**Objection to Planning Application No 2018/93591 – 2<sup>nd</sup> scheme**

**“Erection of restaurant/café/bar, six guest rooms, exhibition/interpretation room, WC’s, terrace, car parking and ancillary accommodation (within the curtilage of a listed building)”**

Drawing
Proposed Site Plan

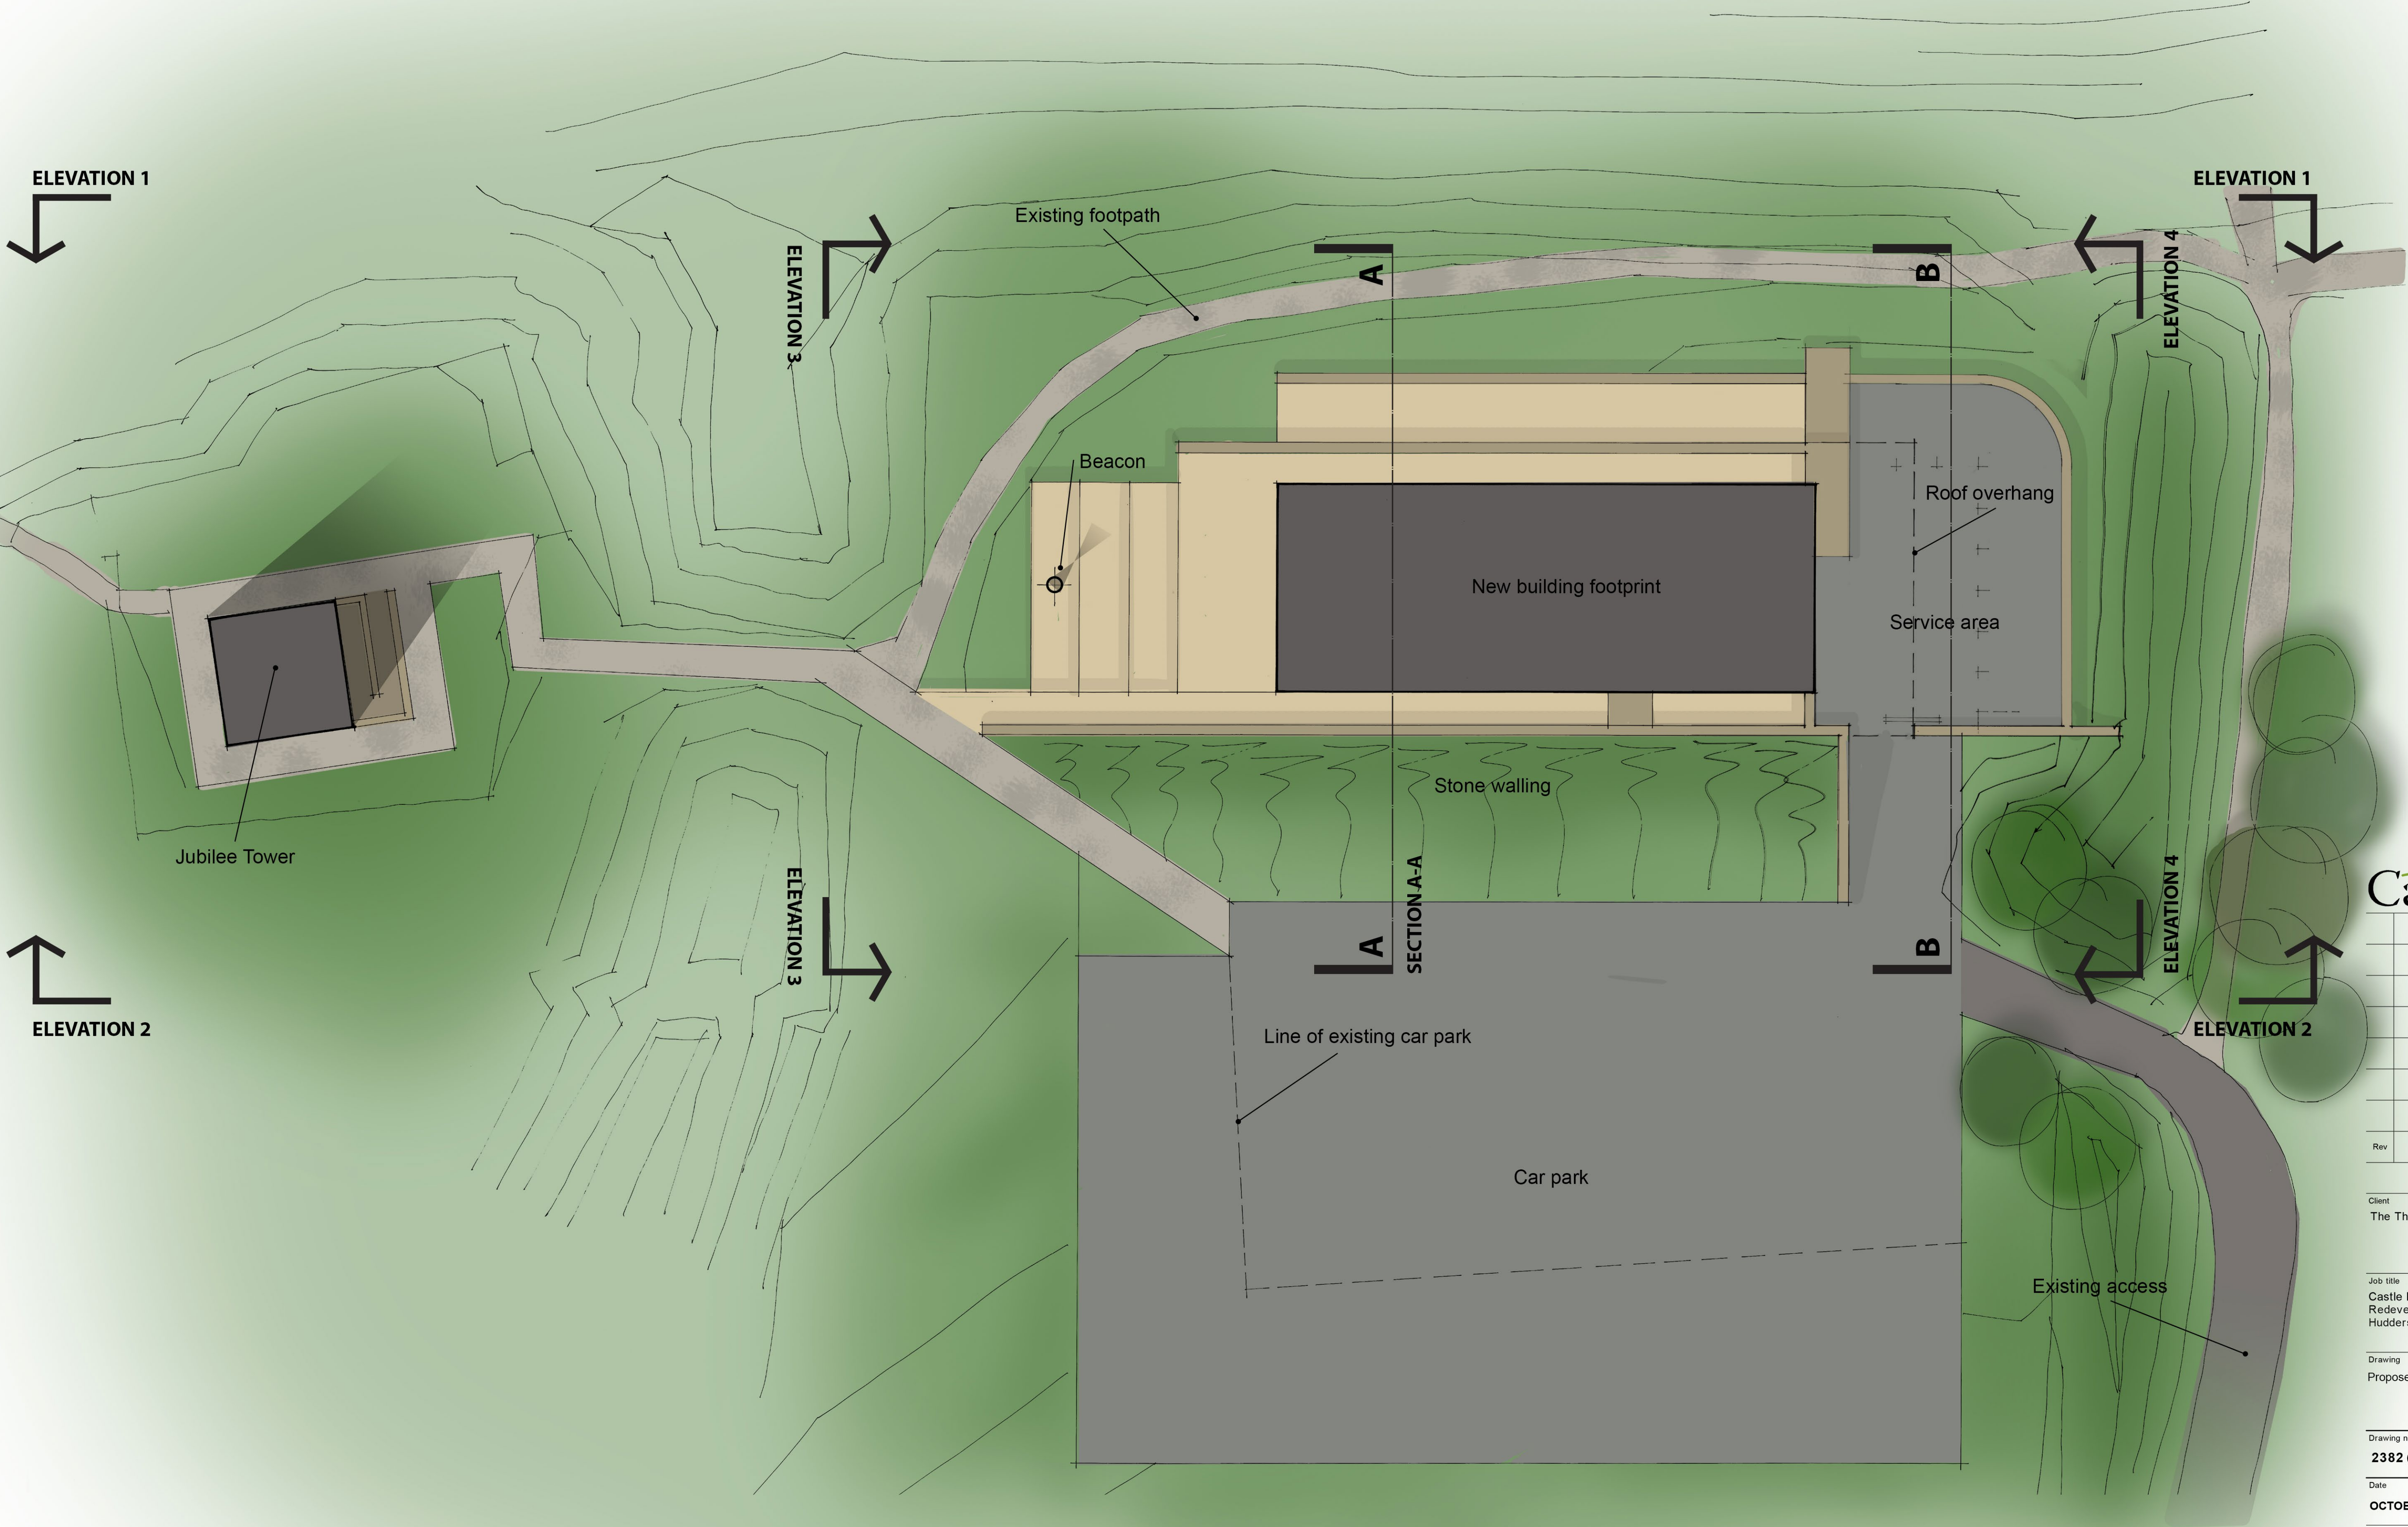
No levels have been provided on proposed sections and plans. An accurate assessment of the impact of "above ground" built forms ie the terrace and restaurant/bar is not possible. Similarly the new plans are not shown in relation to the previous footprint. So the full impact of the scheme on the profile of the hill and on the setting of Jubilee Tower cannot be determined. Similarly long distance views have not been provided. Whilst the building seeks to be physically less obtrusive in views than previous proposals, it would add another element into the setting of Tower, thereby diminishing the dramatic impact of the Tower as a stand-alone landmark.

No proposals have been put forward to improve existing poor quality hard-surfacing or to diminish the effect of the extended car parking area. Overall the design is a poor response to this extra-ordinary landscape. **Proposals demonstrate yet again that it is not possible to introduce this amount of commercial development on Castle Hill without significant harm to the special character of the place.**

The amount of detail provided should be sufficient to assess the impact of proposals on the site and its surroundings. Levels should be shown on the vertical section and plans of the building so that impacts on both physical fabric and views of surrounding assets can be assessed. The block plan should show the whole site and indicate where previous recent development has been.

Proposed Basement Floor Plan 1:100

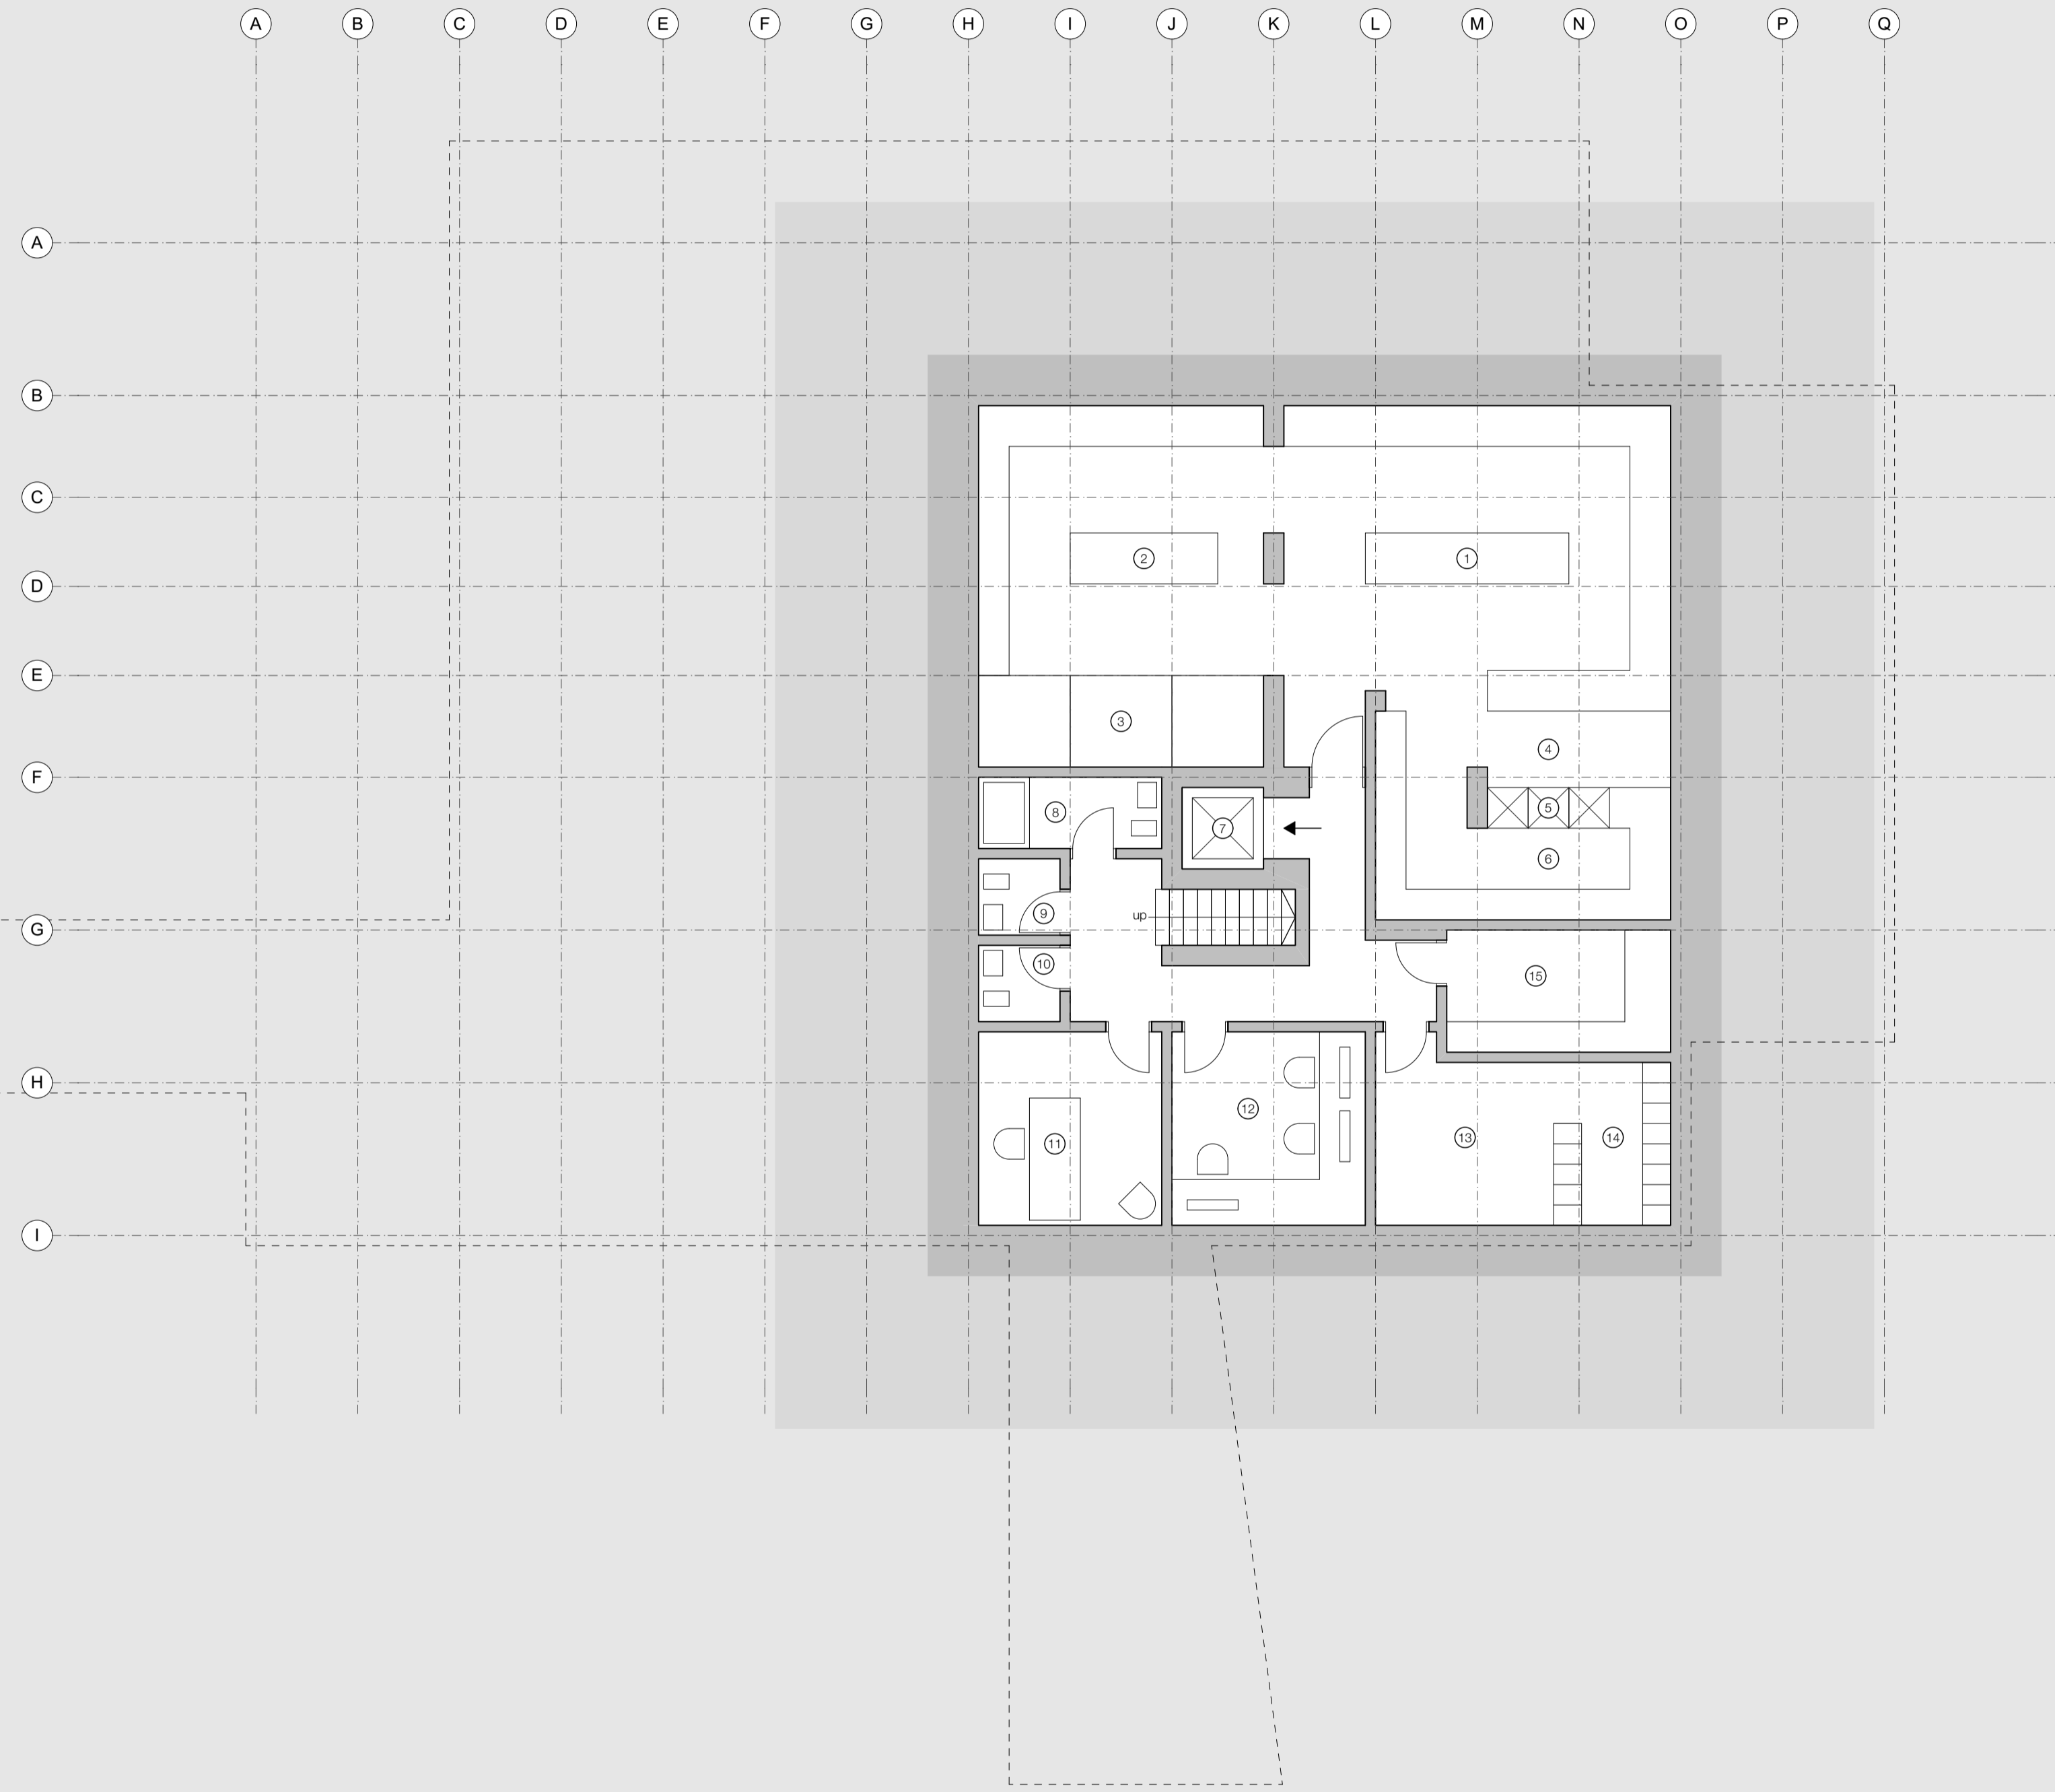
The building is an extraordinary combination of subterranean rooms on two levels situated below a low building of domestic character with raised external terraces. It appears that a reaction to the sensitivity of the site's prominence has resulted in the majority of accommodation being buried underground which in turn is highly damaging to the archaeology itself. There would be very little outlook from working areas and no views from the bedrooms. Fire-escape would appear to be inadequate. Ramps and external yards would form secluded areas outside the building where security and safety concerns have not been addressed or designed out.

Servicing requirements can be substantial and obtrusive. There is no indication of ventilation intake and outflow, especially to below ground areas; kitchen filters and extract flues have not been shown; laundry extract is not shown; there is no indication of the extent and type of external lighting whether for
